Planning Consultation Memo

Date	Planning Officer	Environmental Health Officer
22/09/15	Mark Peacock	Karl Riahi
Planning Application Number	Worksheet Number	
S6/2015/1061/MA	WK/70581

Address: Plot 6000, Hatfield Business Park, Hatfield

Application Details: Erection of a private healthcare facility (Use Class C2), together with car parking, cycle parking, boundary treatment, landscaping, lighting and access

The Proposal: Site Layout

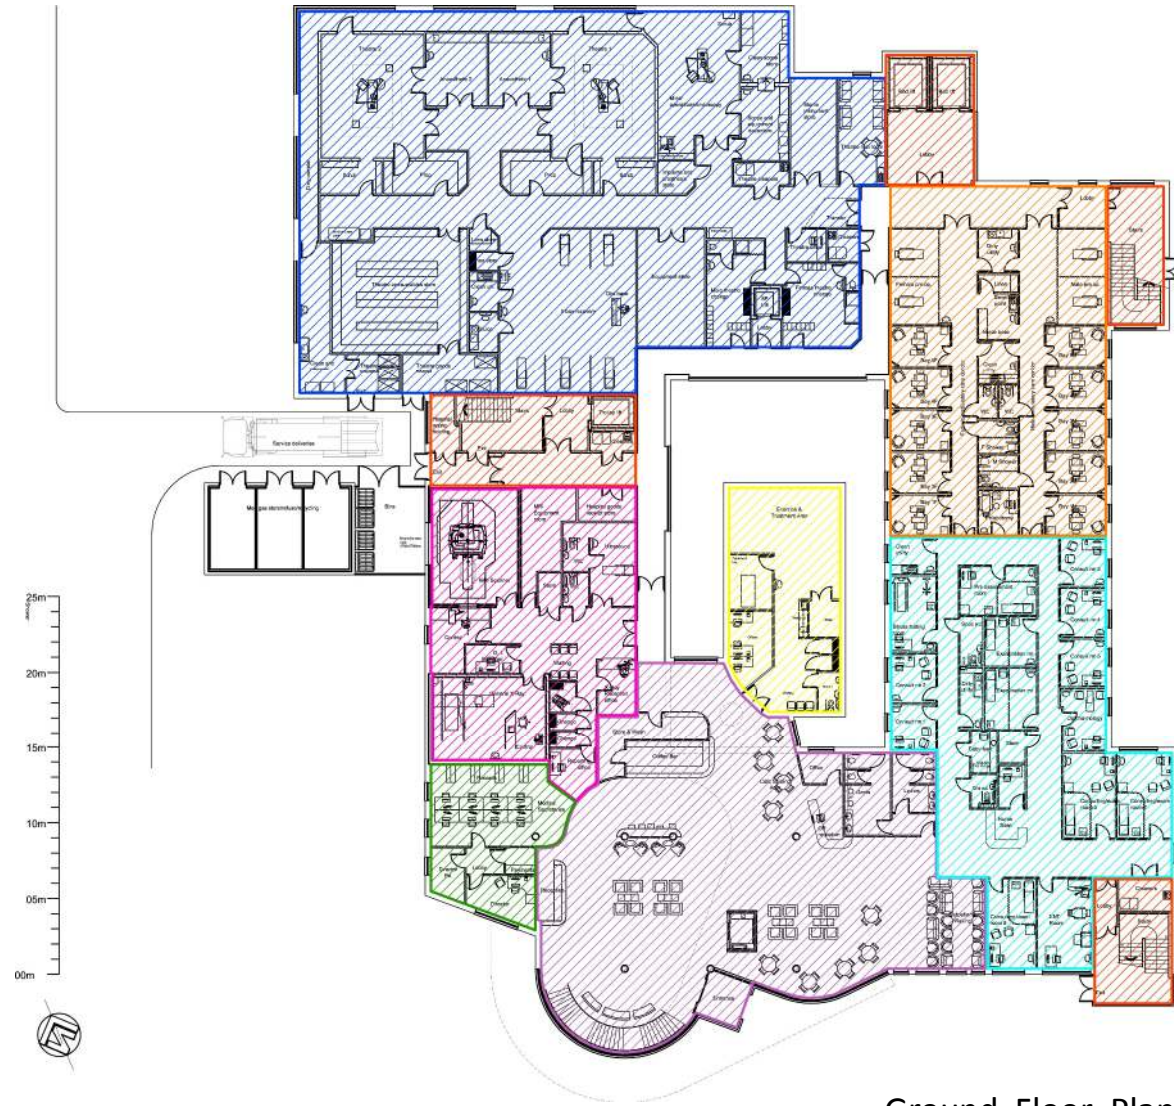
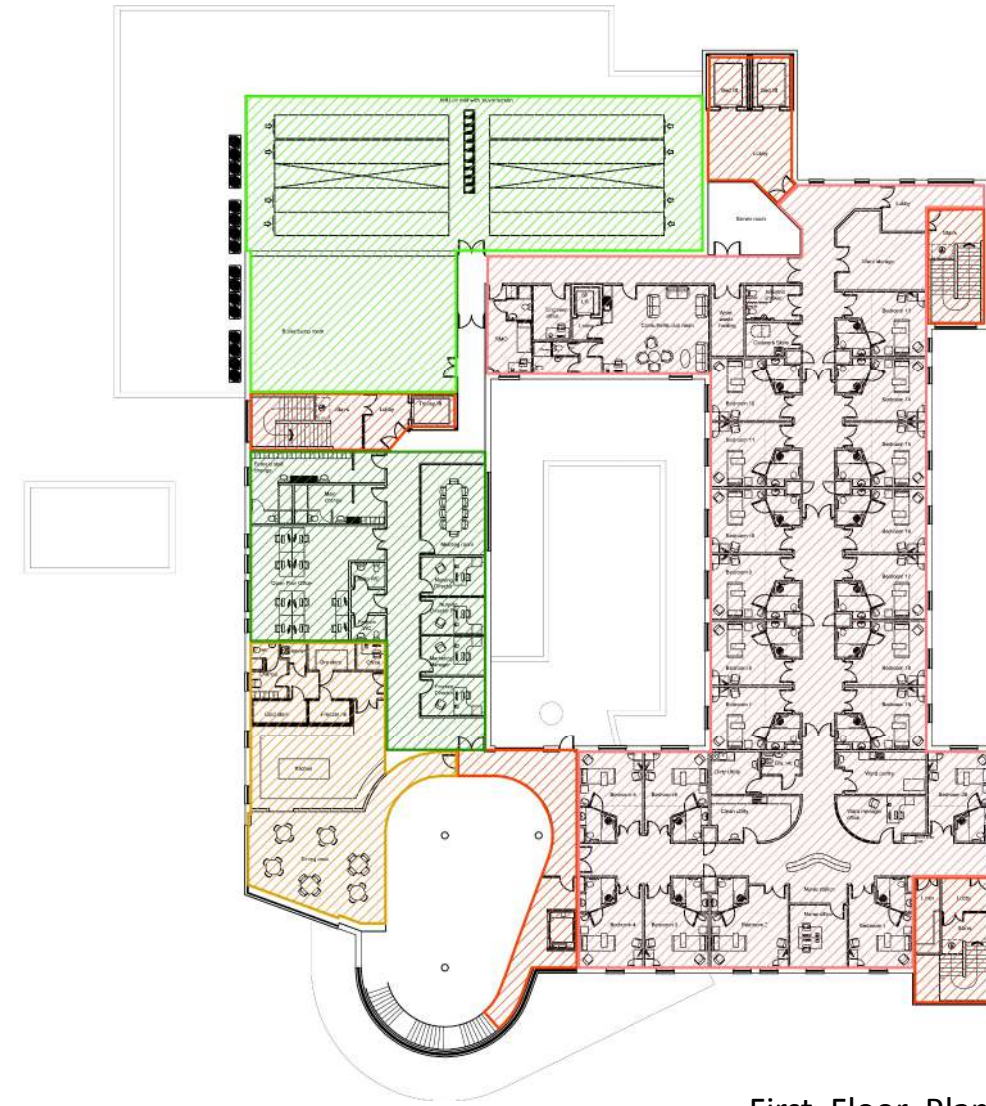
From the main site plan, it appears that there will be an element of shielding of the delivery activities due to the building envelope blocking the line of site of this area. However, it is still expected that noise from deliveries at unsociable times will have the potential to cause a loss of amenity at the closest residential properties to the site. As such it is recommended that a condition restricting delivery times be placed on the application.

Deliveries to the proposed development are to not take place outside the hours of 7am to 7pm on Monday to Saturday and 10am to 7pm on Sundays.
